WEST YORKSHIRE POLICE

To: Bill Topping	Ref: 2018/93825 Date: 21 st January 2019
------------------	--

Site Location: Cleckheaton Mills, Bradford Road, Cleckheaton BD19 5BD

Application Type: 114 Dwellings

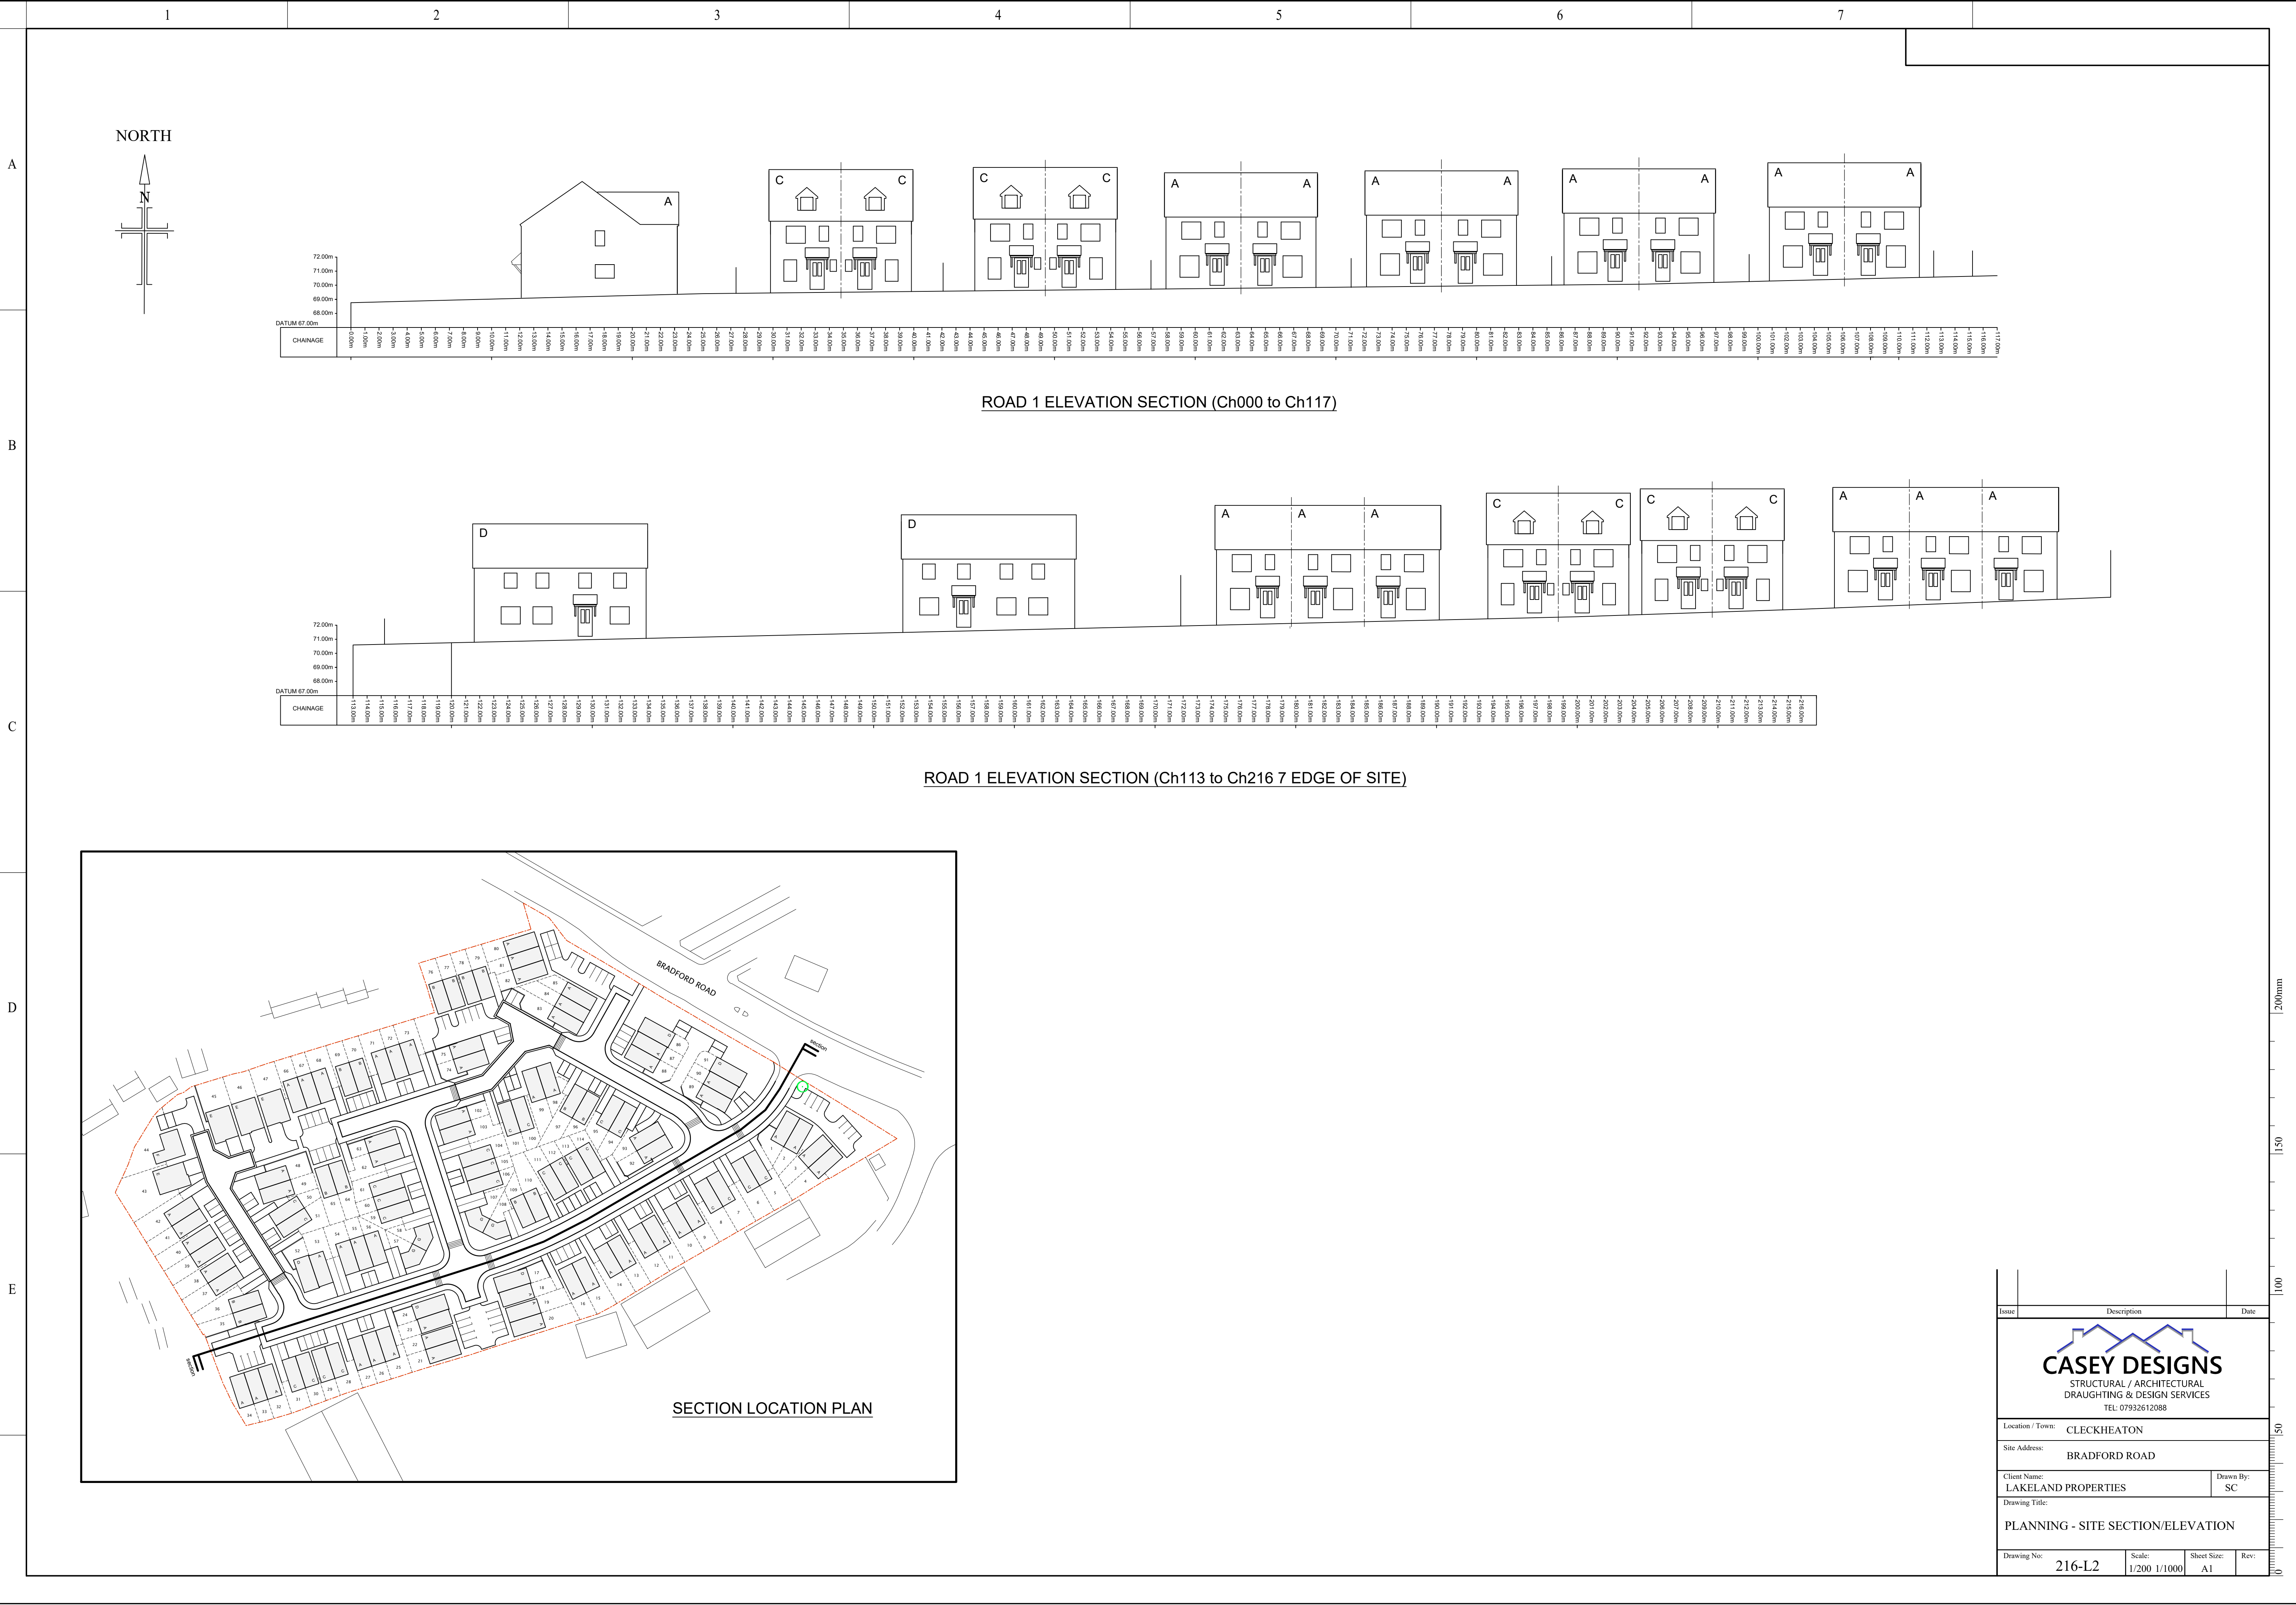
Referring to site plan drawing number 216-L1.

The overall layout of the site affords for good natural surveillance in general for properties and gardens. I have concerns with a number of properties where the drive is not overlooked by either the plot property or neighbouring properties. Plots 35, 36 and also plots 44, 45 are just two examples where the drive cannot be seen from the property clearly.

The main road into the site from Bradford Road is quite straight and may encourage residents to drive too fast towards the site exit. I would recommend that the shaded areas showing block paving are elevated higher than the road surface to create a speed ramp effect to help to keep vehicle speeds down.

Plots 86 to 91 allow for easy access to the rear gardens of each property from the road. These properties should be brought together so that the gardens back onto each other. Parking spaces should be positioned in front of each of the properties to afford maximum surveillance for the parked vehicles.

To the west of this site there is a public right of way. This footpath allows for the free movement of offenders and affords them cover to gain entry into the rear of properties both existing and proposed dwellings.

Along the length of this right of way, I would recommend that plots 35 to 43 are turned around 180 degrees. The road should then run adjacent to the existing footpath with the fronts of plots 35 to 43 now facing the footpath and road. This would make the rear of the properties much more secure with overlook at the rear from properties behind. Re-positioning of plots 48 to 53 would have to be considered to accommodate this.

The boundary fencing to the rear of 35 to 43 and 86 to 91 should be at least 1.8m in height with an additional 500mm of trellis topping to deter climbing should the planned layout remain the same.

With the current status of this planning application, I would recommend that the below measures are implemented to reduce the possibility of burglary on what will become vulnerable properties between plots 35 to 43 and 86 to 91 in the planned layout.
